07 November 2018
Our Ref: 2018_10_10-458
Your Ref: 20010675

Responses to the Examining Authority's Written Questions - Eastern Inshore Fisheries and Conservation Authority (Eastern IFCA)

The role of the Eastern IFCA is “to lead, champion and manage a sustainable marine environment and inshore fisheries” in our district, which extends from the Humber to Harwich, and six nautical miles out to sea. The nearshore section of the Hornsea Project Three Cable Corridor lies within the Eastern IFCA district.

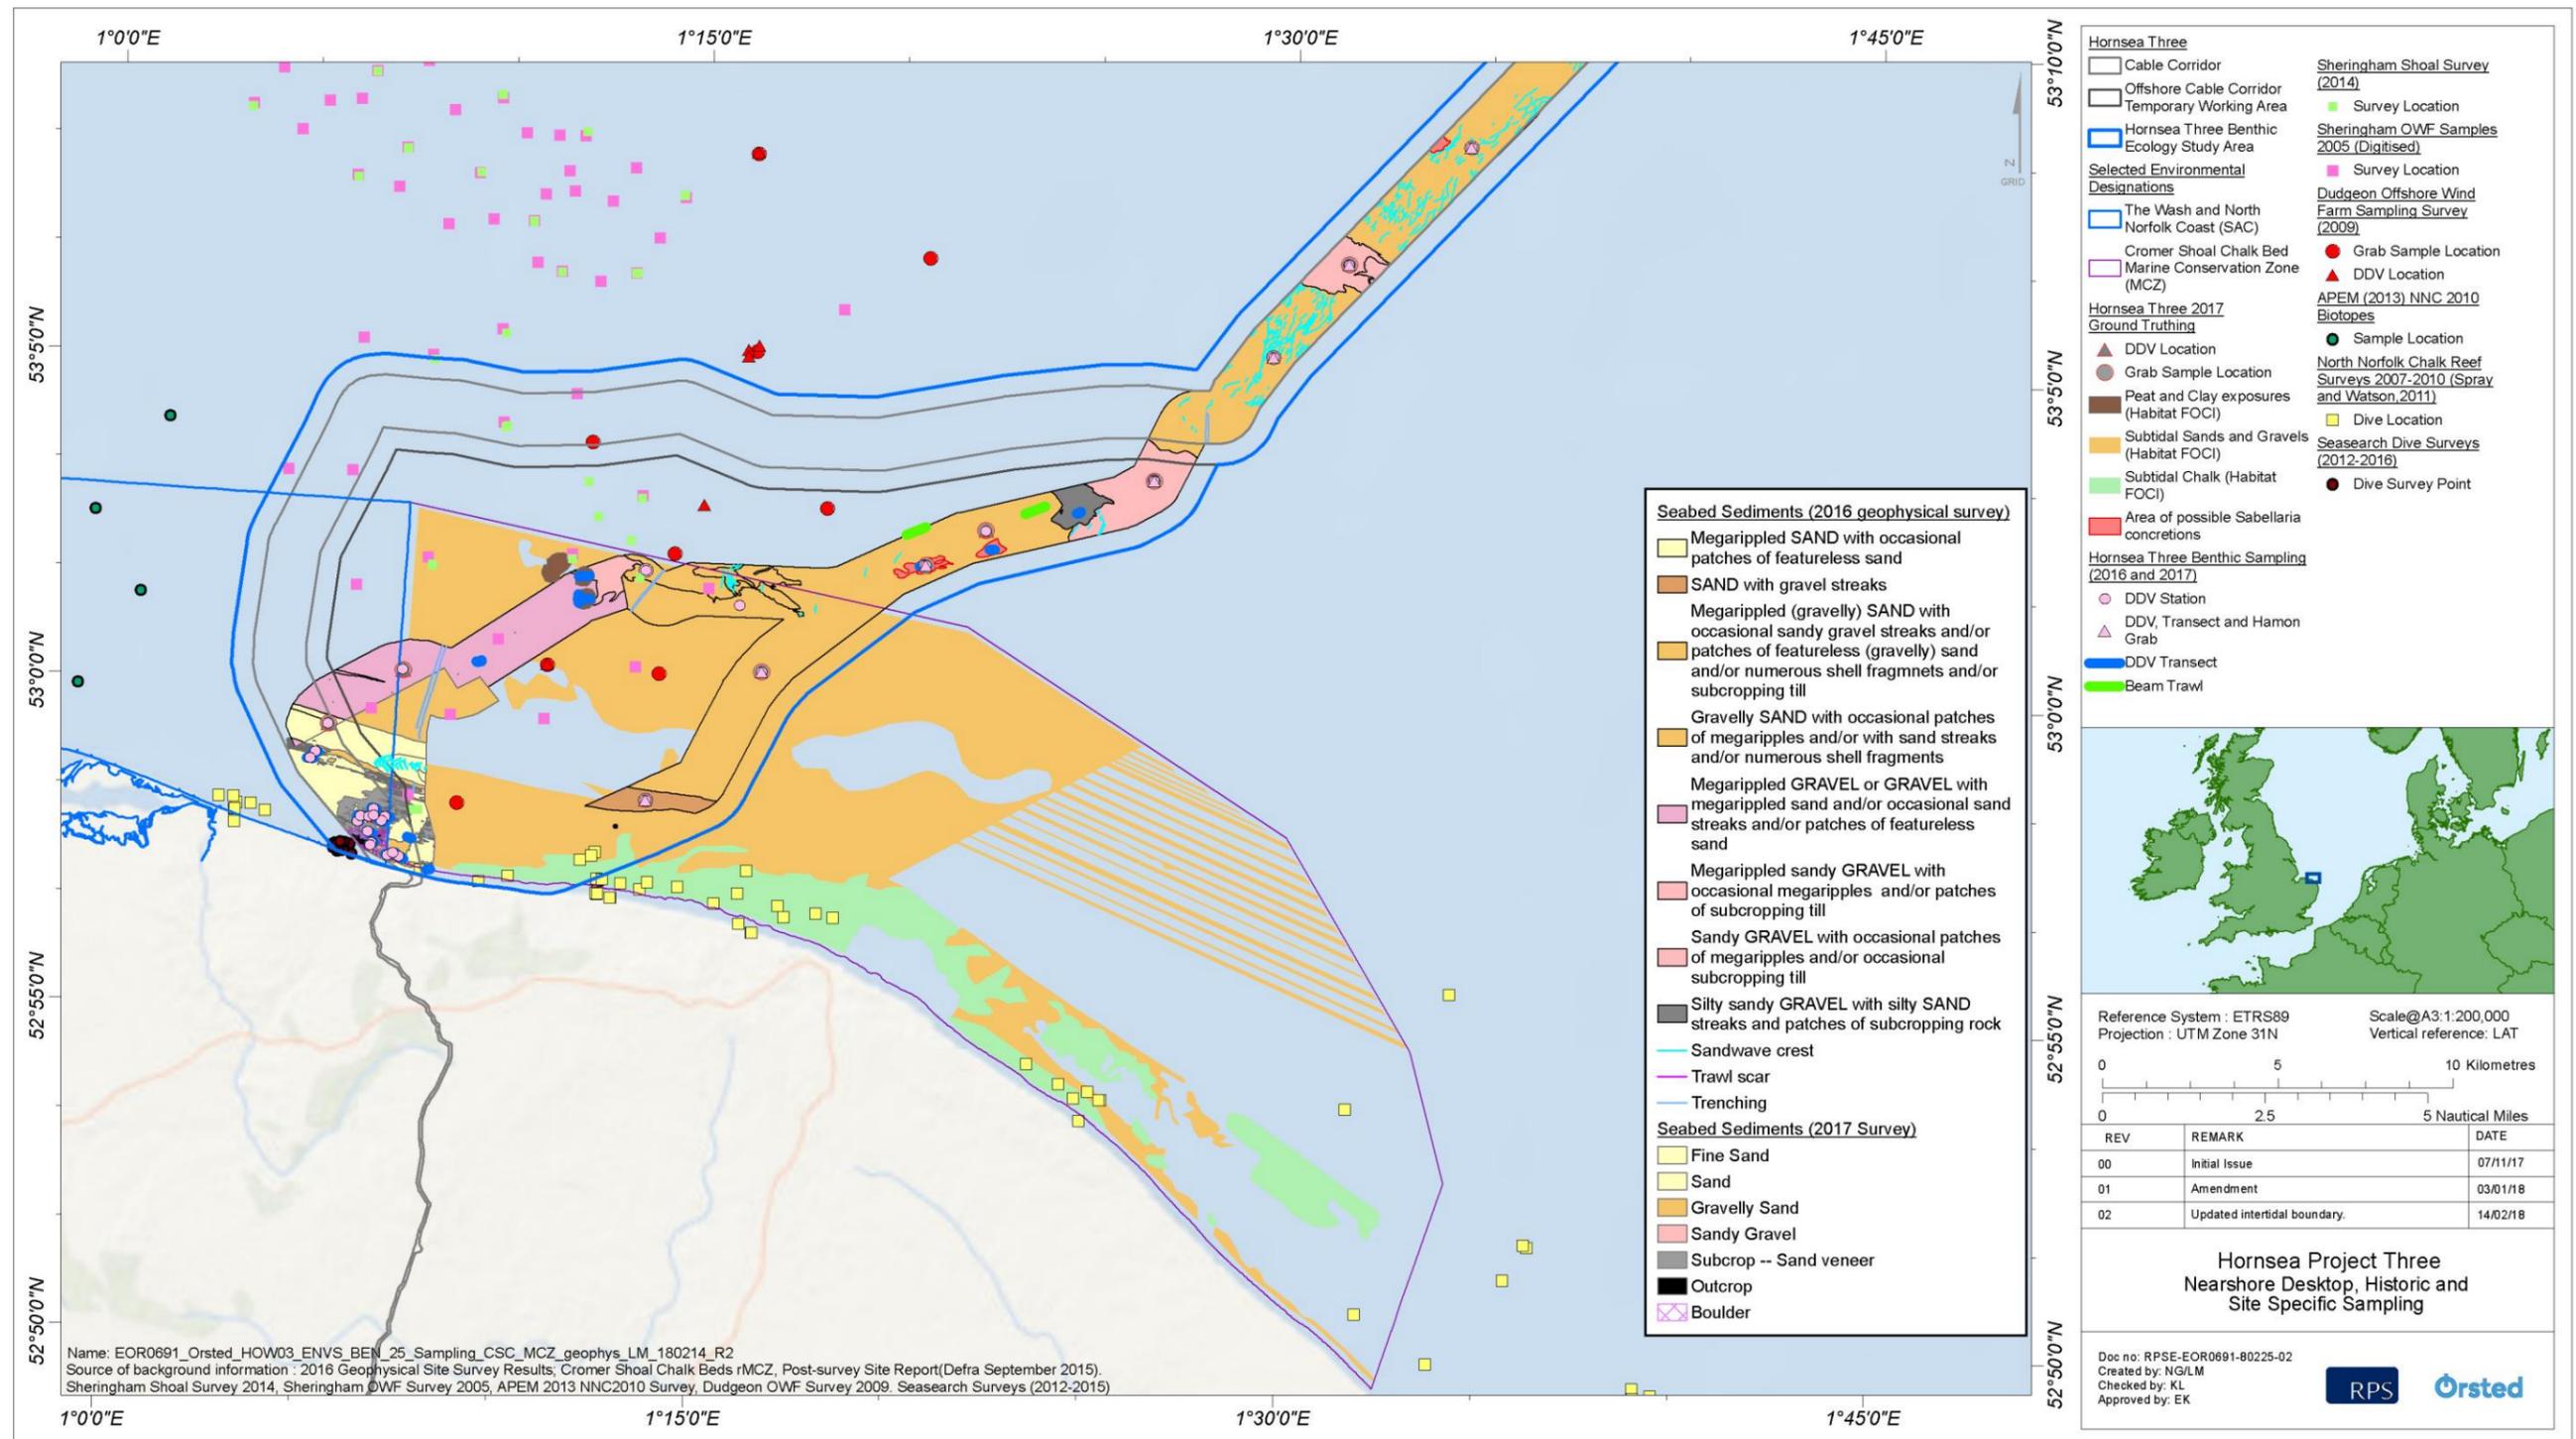
The Applicant used a combination of Hornsea Three site specific data and desktop data sources to characterise seabed types within the nearshore section of the cable corridor. Hornsea Three site specific data however, did not extend into the re-routed area of cable route that runs through The Wash and North Norfolk Coast Special Area of Conservation (SAC) (Figure 1). Biotopes (habitat type supporting particular species) in this area were instead determined by using desktop data sets to extend the nearshore biotope maps generated from the Hornsea Three site specific benthic ecology data into the re-routed area and provide the baseline characterisation for the Environmental Impact Assessment (Paragraph 2.7.6.2. of Volume 2, Chapter 2: Benthic Ecology). Whilst desktop data indicated sediment types were broadly similar across the area with sandy sediments inshore grading into coarse/mixed sediments further offshore, providing the applicant with confidence in the extrapolation, Eastern IFCA do not consider this provides the required level of confidence to enable impacts

In addition, the assigned biotopes differ considerably from those shown in Natural England's latest feature extent data for the SAC (June 2018 data release) (Figure 1). However, the data used by Natural England to inform the feature extents are also considered low confidence, as they have been taken from broadscale habitat mapping surveys conducted prior to 2000 (Foster-Smith *et al.*, 1999) at a much lower spatial resolution than that required to

The fact that biotope data have been extrapolated from point data and surveys pre-dating 2000 means there is low confidence in the type of habitat in the nearshore cable area. Therefore, either site-specific surveys should be undertaken to ascertain the actual habitats present, or a precautionary approach should be taken to managing activities in the area to ensure potential impacts on most sensitive habitats cannot occur.
